Email: ecology@lancashire.gov.uk
Your ref: CONECO/3/2012/0578
Our ref: 03/12/0578/ASM/ASP/RS
Date: 22nd August 2012

Ecological comments

Planning Application No: **3/2012/0578**
Proposals: **Development of outdoor adventure centre**
Location: **Devil's Elbow land off Whalley Road (A671)**
District: **Ribble Valley**

320120578P

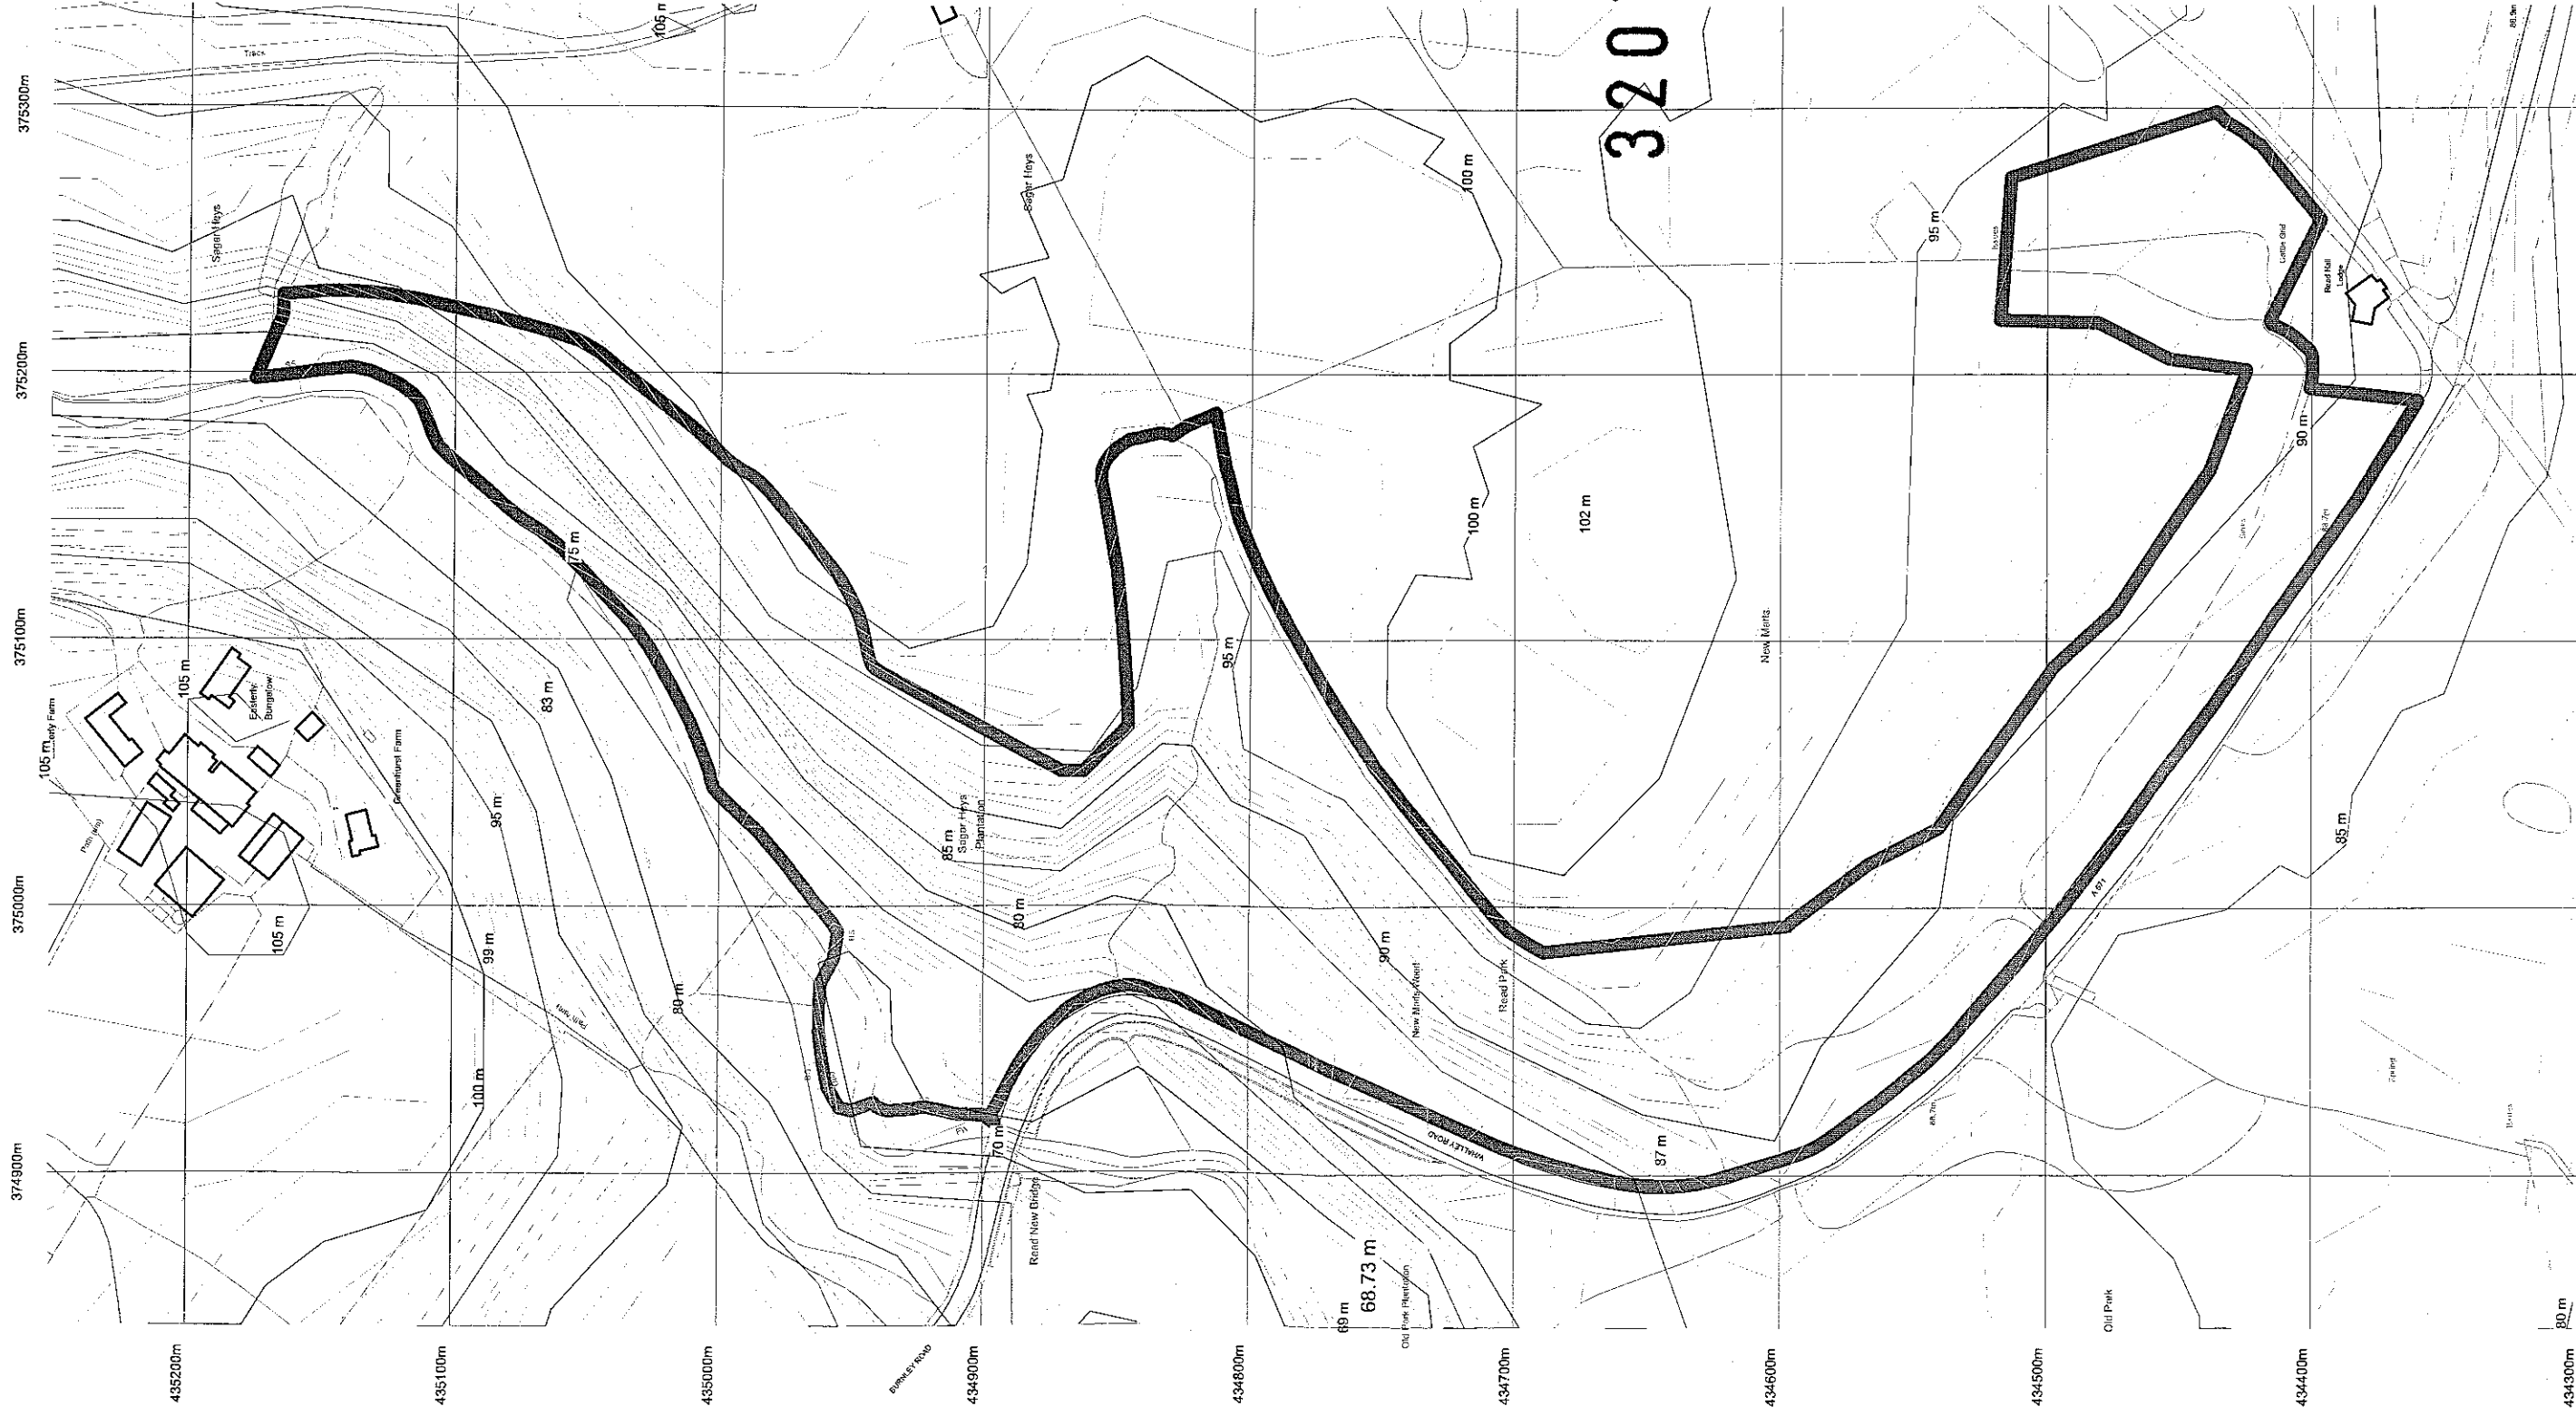
- Fully detailed proposals of the tree top route, other routes/trails, exclusion zones, and access restrictions should be submitted prior to approval in order to allow ecological impacts to be assessed before determination.
- The proposals affect a woodland which is thought to be ancient in origin and which is part of Old Park Plantation, New Marls Wood and Sager Hey Plantation Biological Heritage Site (BHS 73SW10). Further details, including access proposals (see above), are required to demonstrate that there would be no impacts on the woodland and additional qualifying features of the BHS or that any impacts would be

- Clarification is required on the location and design of proposed fencing / barriers. This information is required prior to determination as installation of fencing/barriers may restrict movement of badgers and other wildlife.

It is proposed that access is limited and strictly controlled to areas identified by the ecological consultant as being of high ecological value (Planning Statement para 4.27). The Design and Access statement states that access to these areas will be restricted to educational and research usage by permit only. However the statement then goes on to say that the nature trail will be established to follow existing footpaths with no access to the woodland allowed beyond designated areas allowed except by permit. It is not clear to me from this whether all access will be restricted to the northern area of woodland or whether the restriction will only apply to access away from the proposed trails/footpaths within the northern area of woodland. The design and access statement also states that education walks will focus on the less accessible areas of the site, watercourses etc. It is not clear from this whether it is proposed that trails allow access to less accessible (and more ecologically sensitive areas such as wetland and watercourses) areas or whether this access is off the trails/footpaths.

- Current access by people and dogs, including access/footpath routes and level of use
- Whether dogs will be allowed on site or not, and if so where and with what level of control
- Proposed trail routes
- Proposed exclusion zones
- Area/ecological value of ground flora to be lost/damaged by the creation of trails and the proposed surfacing material of trails
- Level of access proposed, including how access will be controlled/restricted, to and within the northern area of woodland i.e. the proposed numbers/use of both trails and the wider area; how numbers using the trails and numbers allowed off the trails will be restricted in practice; how restrictions will be policed; whether access restrictions will be enforceable.
